**Your Ref:** OWQC14917  
**Our Ref:** BE/83/17/PL  
**Please ask for:**  
Mr S Davis

1 No. dwelling & associated parking.  
Land adjacent to 385 Chichester Road & 24 Ashurst Close Bersted

Thank you for your internet comments made on 4th August 2017 which has been recorded as '**an objection**' with the comments as follows:

DRAWING TITLE
Site Plan and Street Elevations

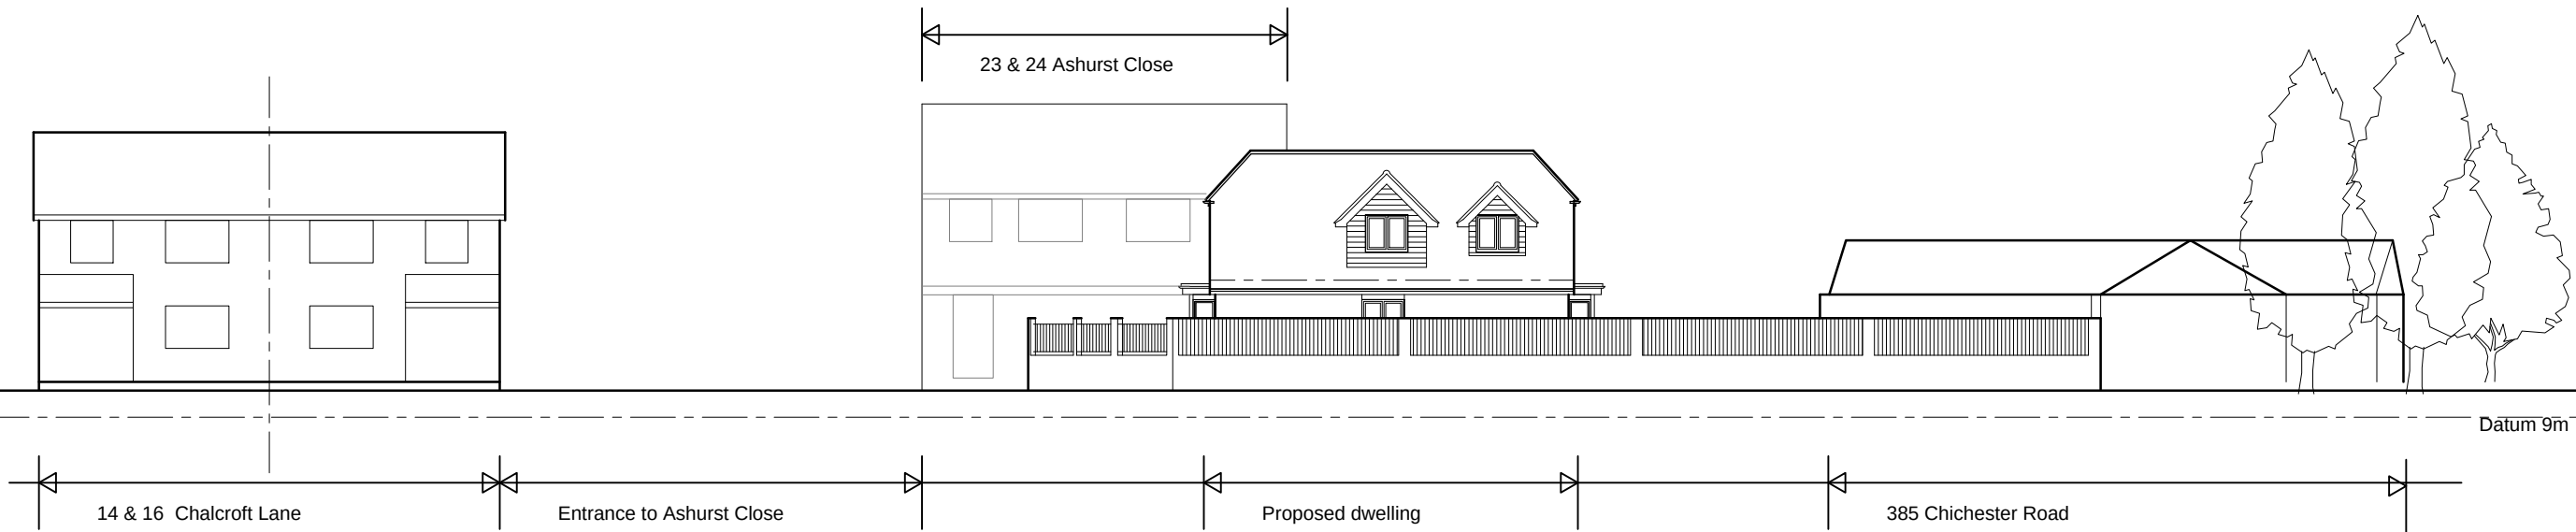
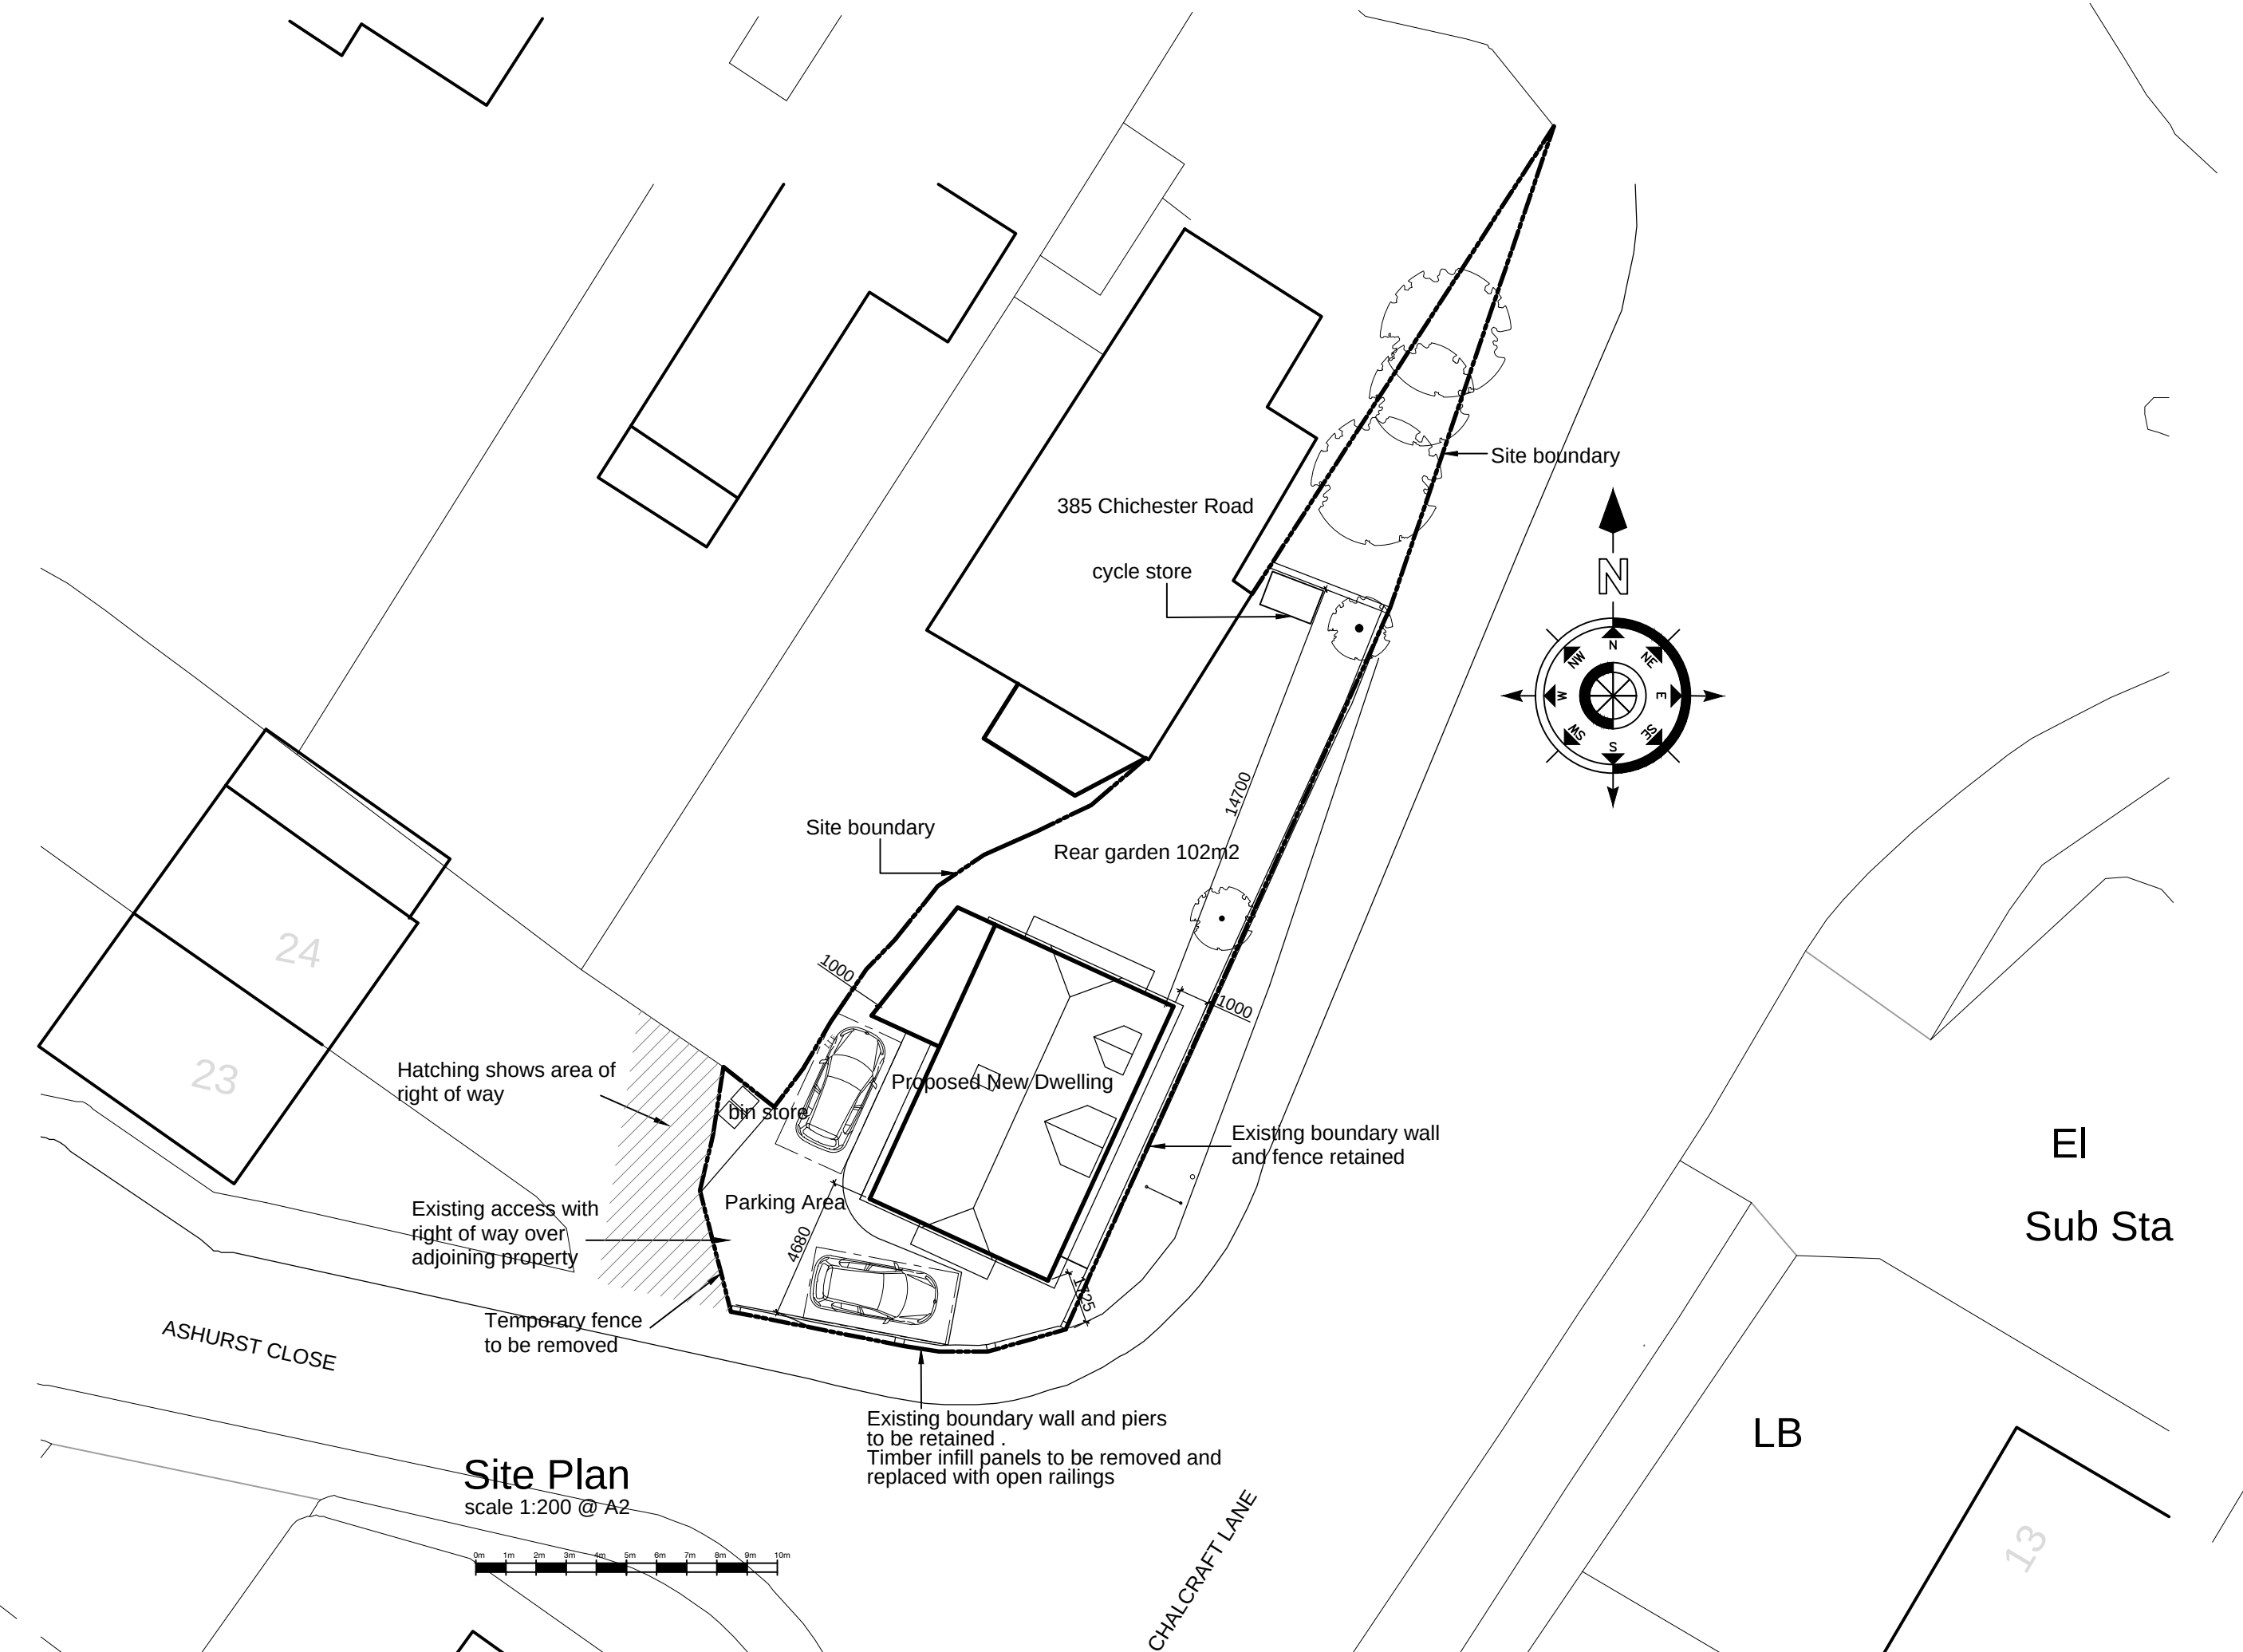
*Object as this is an overdevelopment of the site and highway safety as the access is near the junction with Chalcraft Lane*
